Water for the North West

Your ref: 3/2023/0153  
Our ref: DC/23/857  
Date: 20-MAR-23

**Location: Old Row Whalley Road Barrow BB7 9AZ**

**Proposal: Proposed erection of a 66 bed care home (use class C2) for elderly people with associated parking**

Drainage Layout

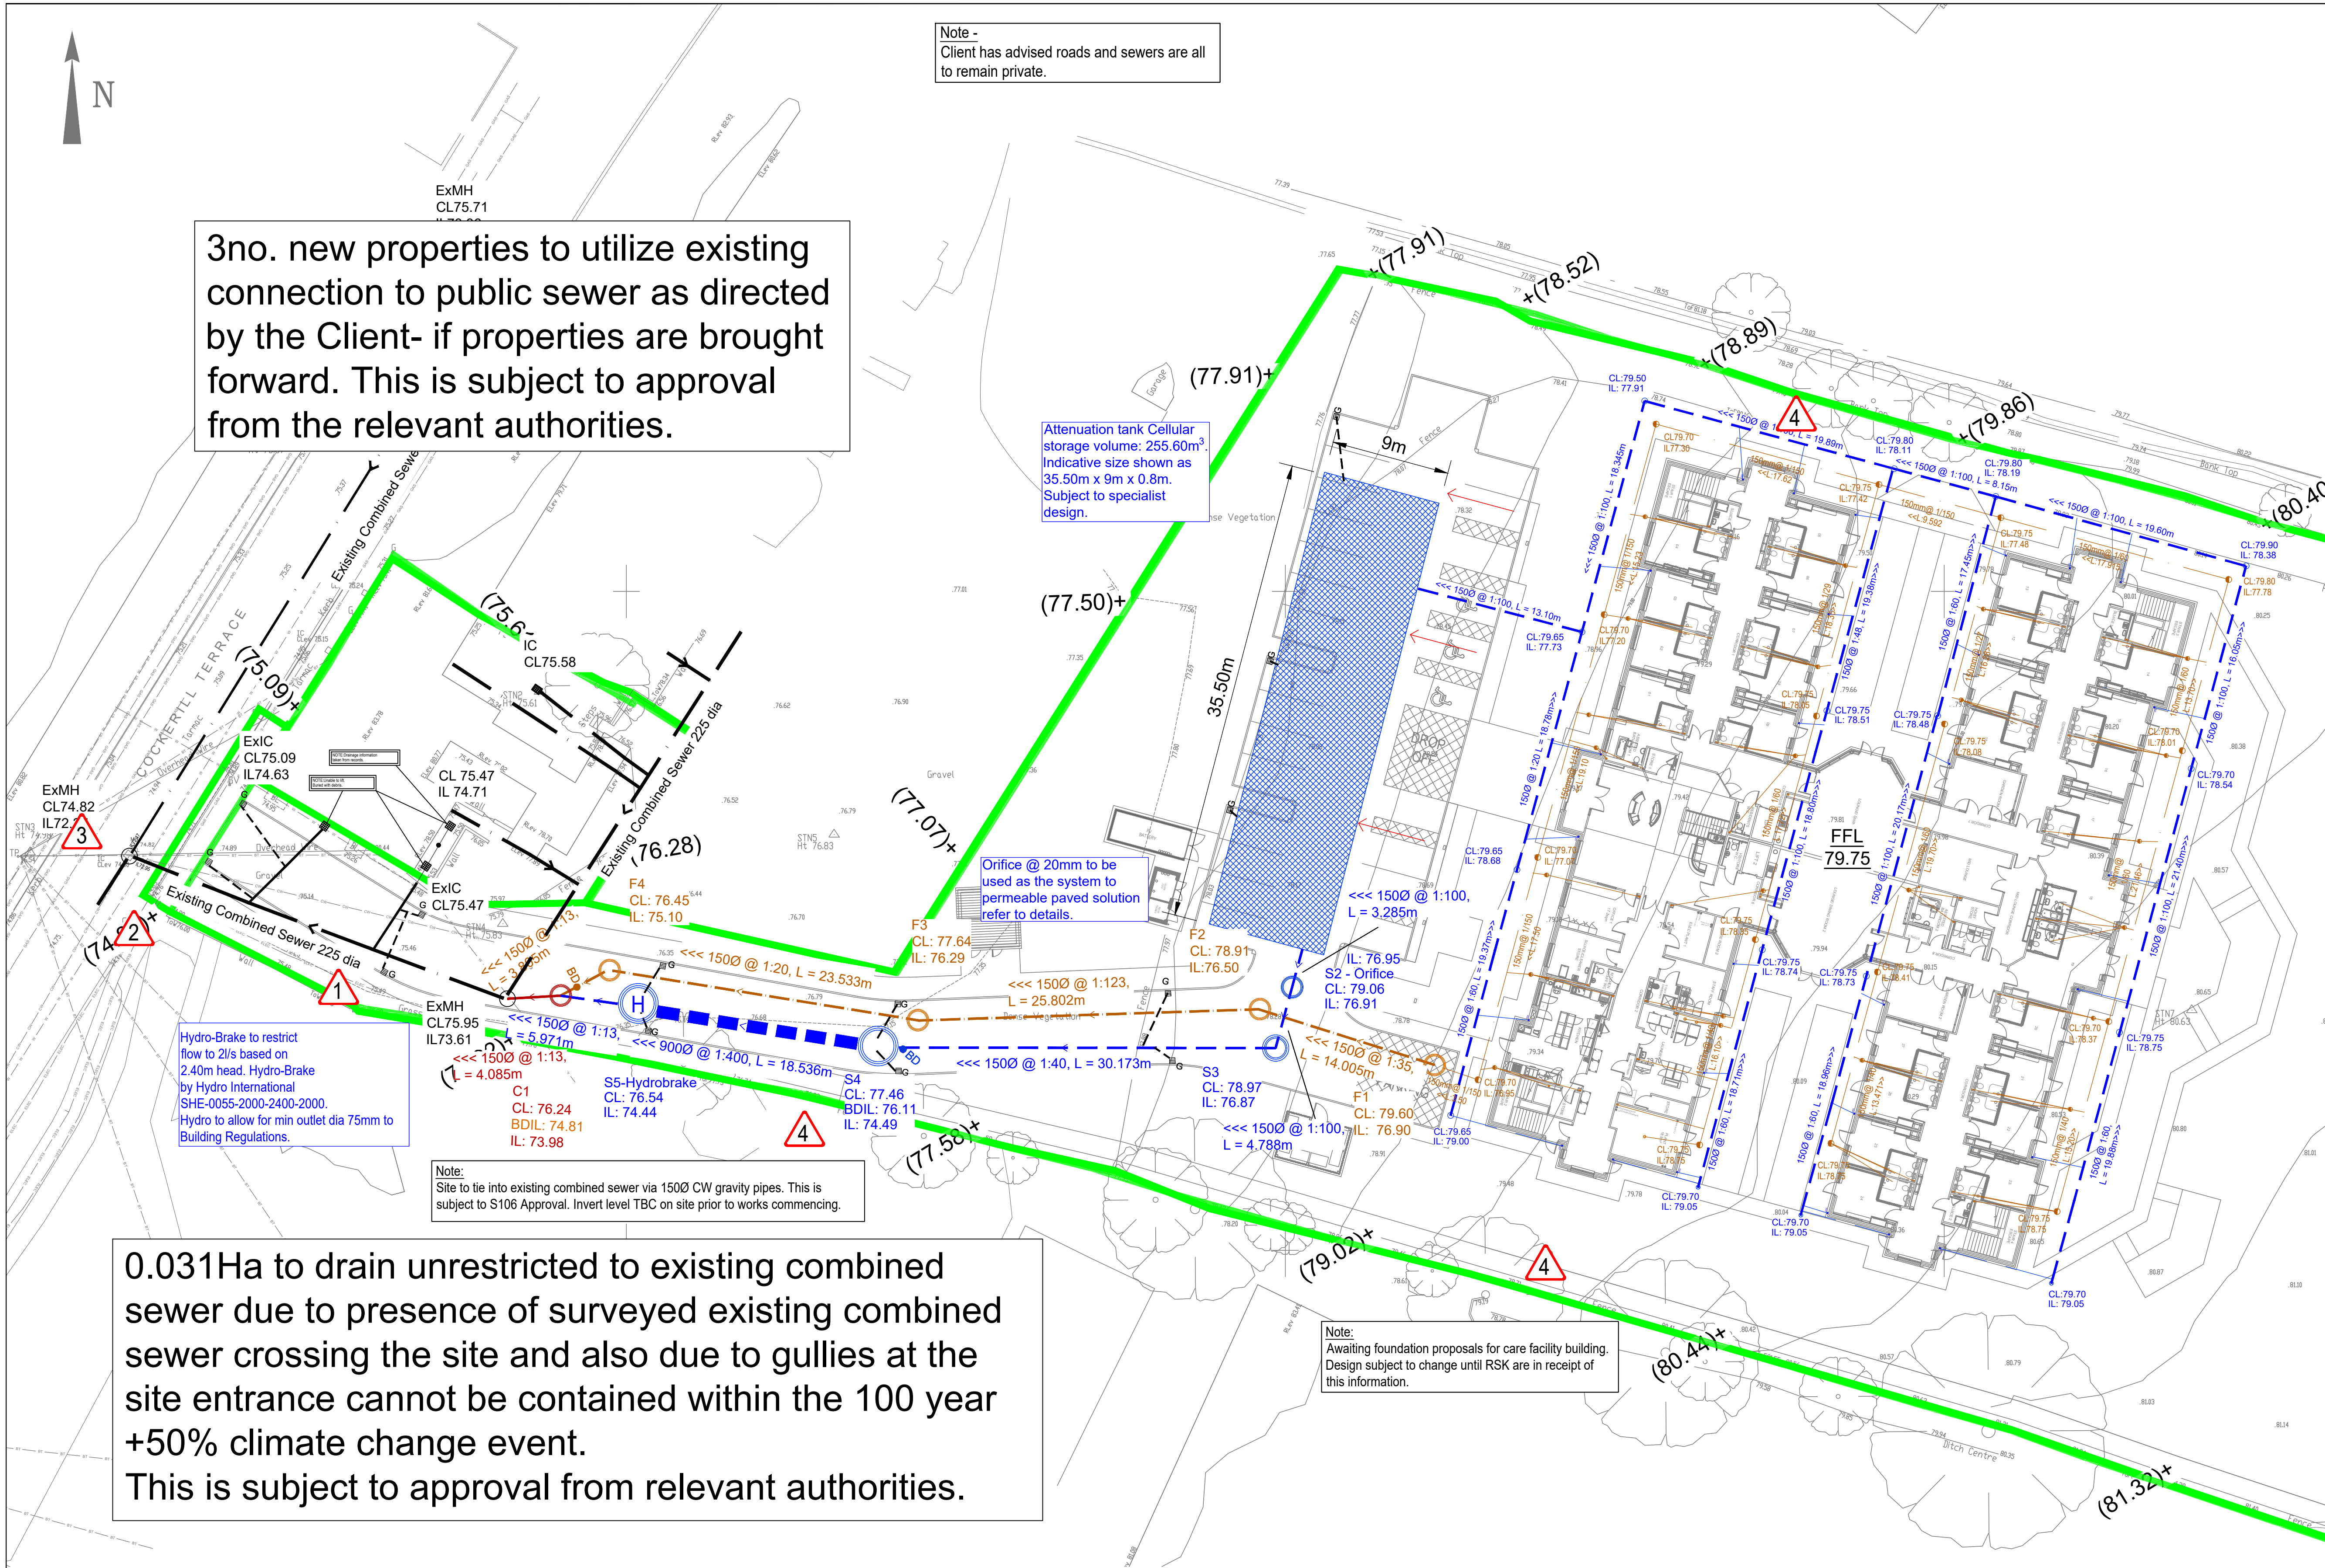
***Following our review of the submitted Drainage Strategy, we can confirm the proposals are acceptable in principle to United Utilities and therefore should planning permission be granted we request the following condition is attached to any subsequent Decision Notice:***

***The drainage for the development hereby approved, shall be carried out in accordance with principles set out in the submitted Foul & Surface Water Drainage Design Drawing 882667/10-01, Rev P1 - Dated 25/01/2023 which was prepared by RSK. For the avoidance of doubt surface water must drain at the restricted rate of 2l/s. Prior to occupation of the proposed development, the drainage schemes shall be completed in accordance with the approved details and retained thereafter for the lifetime of the development.***

Following our review of the proposed site layout, we have concerns regarding the proximity of proposed development to our water assets. To resolve this matter, and to avoid any unnecessary costs or delays to either the applicant or any future developer, we request the applicant submits a detailed site layout plan which overlays the proven location of the water main in relation to any proposed development (including walls, fencing, parking etc.). Without this information we are unable to provide further comment and there is a risk that as the scheme progresses, the applicant, or any subsequent developer, may discover that their plans are not implementable in their existing form or that diversion of assets is required. Therefore, we strongly recommend this matter is resolved PRIOR TO DETERMINATION.

A water main crosses the site. It must not be built over, or our access to the pipeline compromised in any way. We require an access strip as detailed in our Standard Conditions for Works Adjacent to Pipelines, which can be found on our website: <https://www.unitedutilities.com/builders-developers/your-development/planning/building-over-or-working-near-our-assets/working-near-our-pipes/>.

A public sewer crosses the site and we will not permit building over it. We require an access strip for maintenance or replacement and this access must not be compromised in any way. The minimum distances that might be acceptable to United Utilities are detailed within Part H of the Building Regulations however, we recommend the applicant determines the precise location, size, depth and condition of the pipeline as this is likely to influence the required stand-off distance from any structure.
